DECISION DELEGATED TO DEVELOPMENT MANAGER

Application No: H17-1174-20 **Applicant:** Mr C Godderidge

Proposal: Demolish existing bungalow, erect 5 bed detached house with double integral garage and associated external works - approved under H17-0860-18. Modification of Condition 2 to allow amendments to previously approved plans.

Location: 31 Station Road Surfleet Spalding

Elevation 03 - Rear

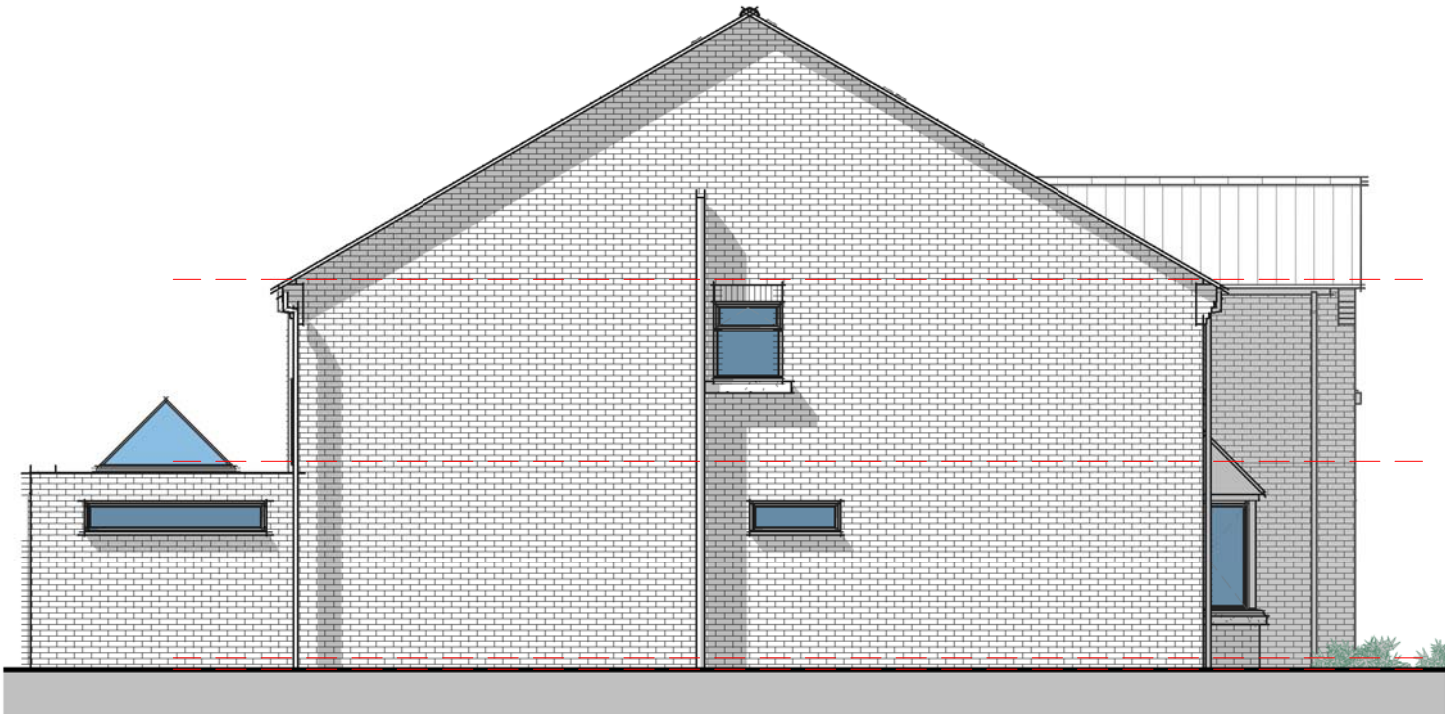
The windows on the western elevation would be to a utility room and two en-suites, none of which are classed as habitable rooms in planning terms. A lounge and sun lounge window are shown at ground floor level on the eastern elevation and a bathroom window at first floor. However there are no facing windows on the neighbouring property to the east. Overlooking is therefore not considered to be a material issue. The ridge height of the dwelling would be marginally lower and the side elevation would be further away from the bungalow to the west than originally approved. There is therefore not considered to be a material overbearing or overshadowing impact as a result of the proposed changes. The removal of the rear balcony will arguably improve the privacy at the end of neighbouring gardens.

The visual appearance of the dwelling when viewed from the front is not significantly different to that previously approved.

The proposed sun room to the rear is of a size that would normally be allowed under permitted development rights, and the window facing east would be high level, thus there are no material concerns in this regard.
